4445 Hagerman Ave, Cascade, El Paso County, CO, 80809

aka *Eastholme of the Rockies*
Bed & Breakfast

RE: Letter of Intent

Special Use Map
Susan & Kevin Taylor
Eastholme of the Rockies
Bed and Breakfast
4445 Hagerman Ave
Cascade CO 80809
-no mineral interests
-Zoned R-T
-No Private Roads

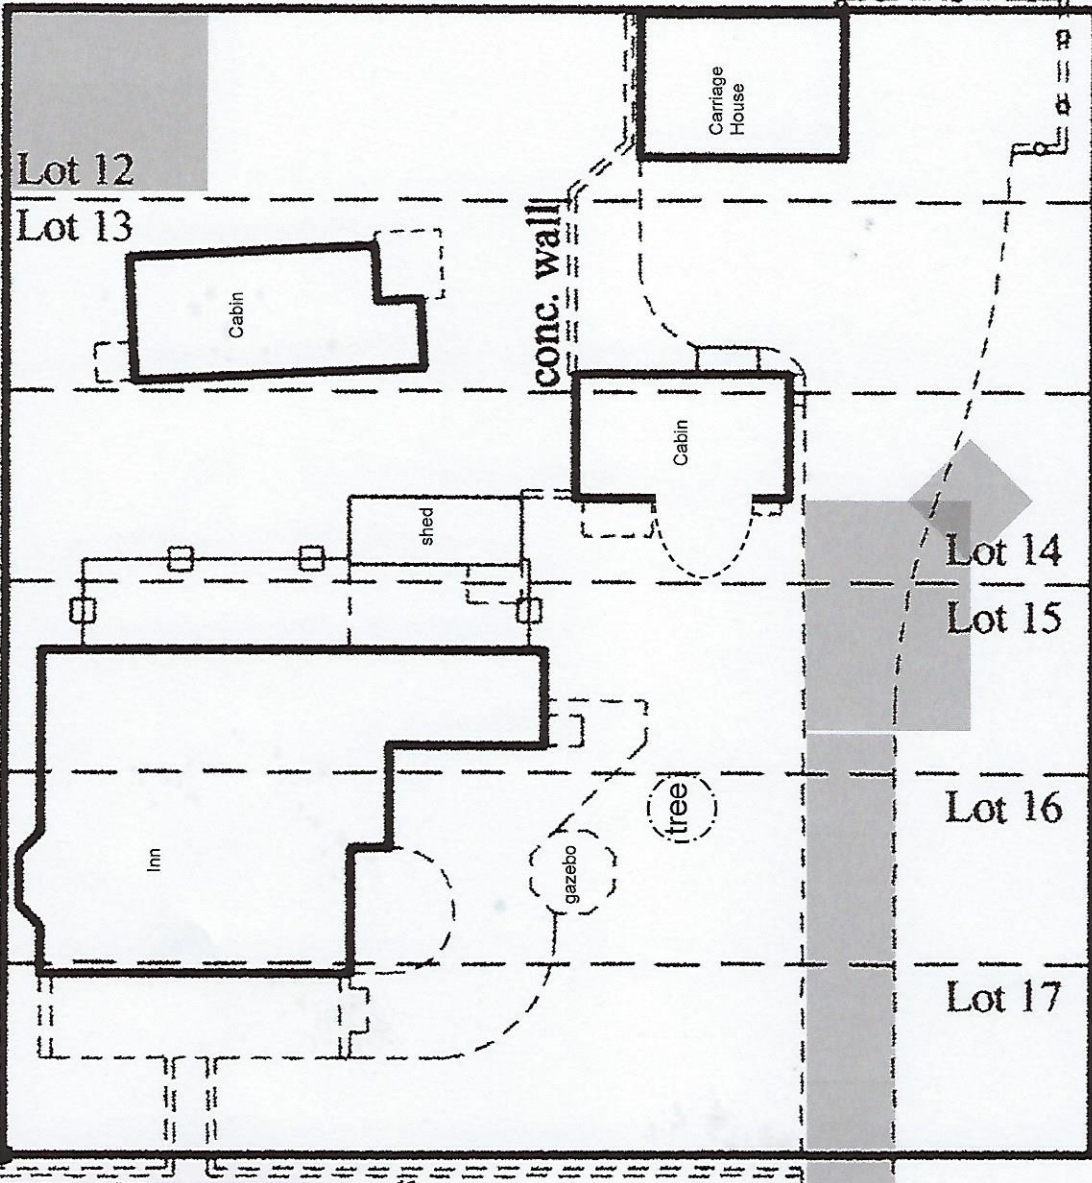
Letter of intent should address the anticipated traffic. It should state where the site I accessed from (which 'public' street). It should address the carriage house as shown on the special use map, enough to let us know the current and intended use.
